WEST SUSSEX COUNTY COUNCIL CONSULTATION

TO:	Arun District Council FAO: Mrs A Gardner
FROM:	WSSC - Highways Authority
DATE:	3 August 2020
LOCATION:	Land at Elmer Road Bognor Regis PO22 6DZ
SUBJECT:	M/49/20/TEL Prior notification under schedule 2, part 16, class A for the installation of a new monopole up to 20m in height supporting 6 no. antennas with a wrap around equipment cabinet at the base of the column, installation of 3 no. new equipment cabinets & ancillary development thereto.
DATE OF SITE VISIT:	n/a
RECOMMENDATION:	Advice
S106 CONTRIBUTION TOTAL:	n/a

PROPOSED SITE PLAN

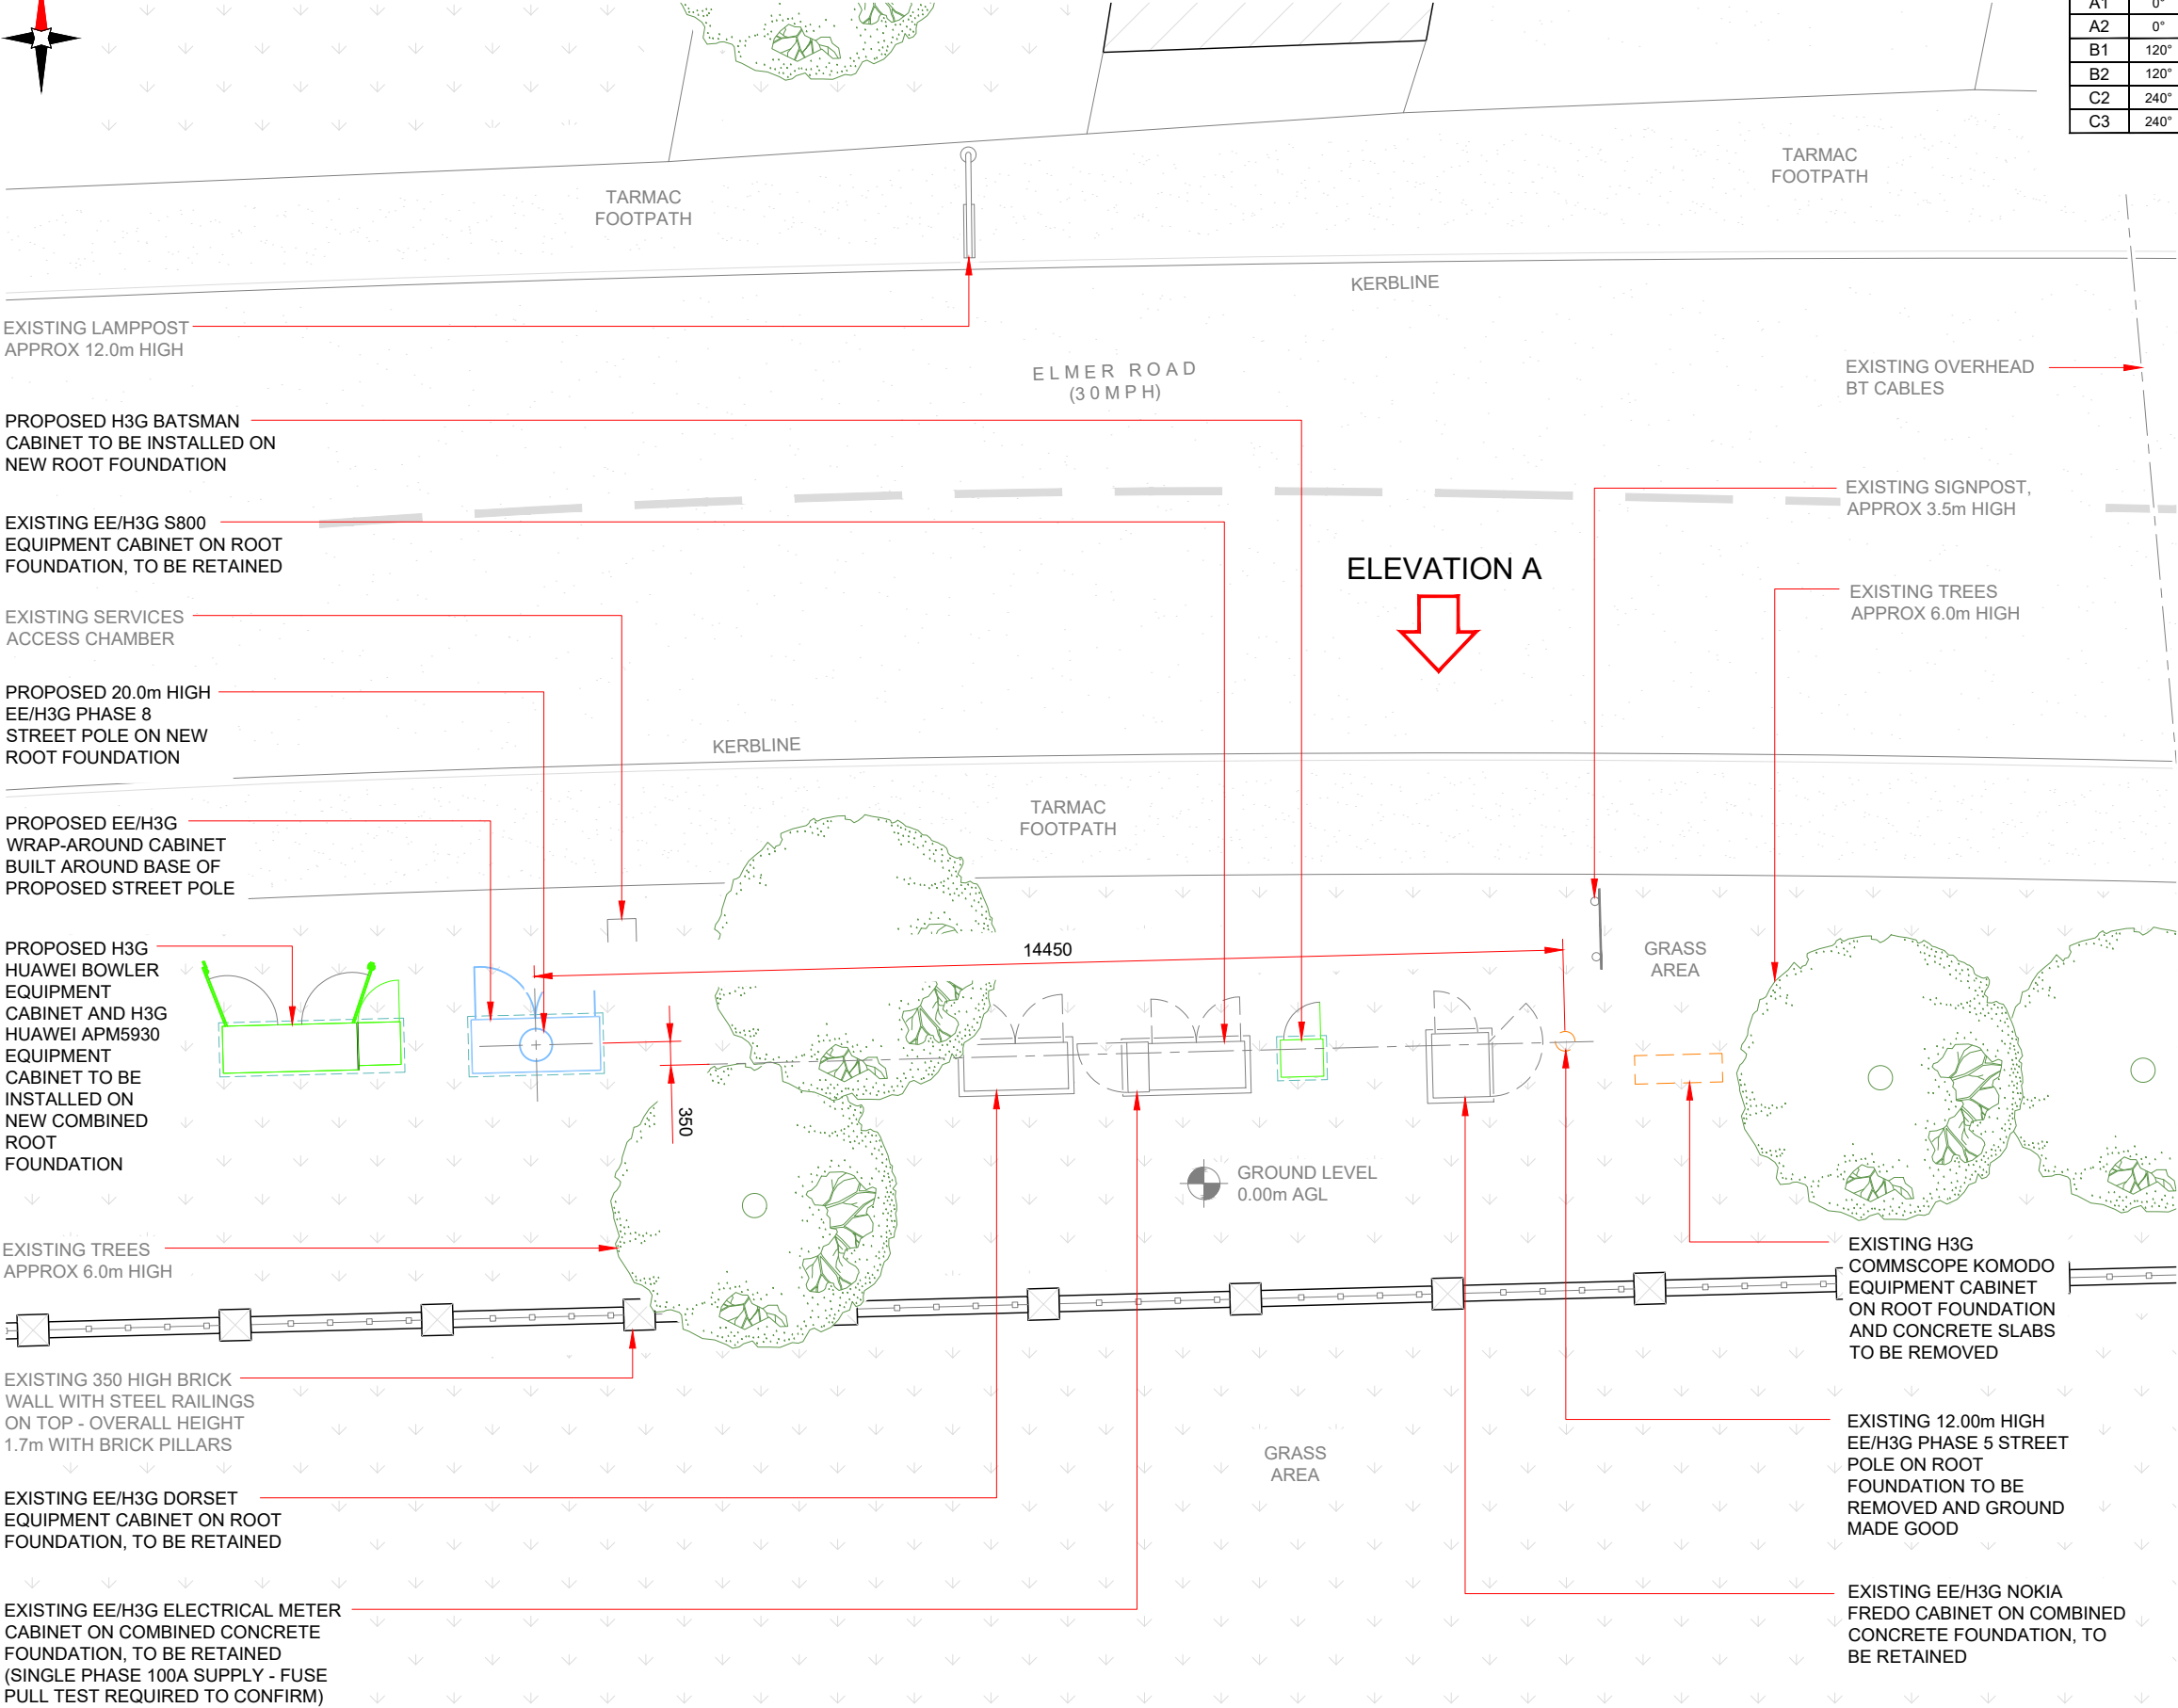
The proposed cabinets and pole are all located within highway boundary and not anticipated to obstruct visibility for vehicles travelling along the Elmer Road. At present there are 4 cabinets and pole installed in this location.

The proposed equipment will be located on verge that has a footway. This proposal is not anticipated to result in an obstruction to any pedestrians who may be utilising or be seeking refuge within the existing footway.

The statutory undertaker will need to submit the necessary notification to the Highway Authority independently and any traffic management will need to be agreed with WSSC Highways prior to works taking place. Their contact details are included below.
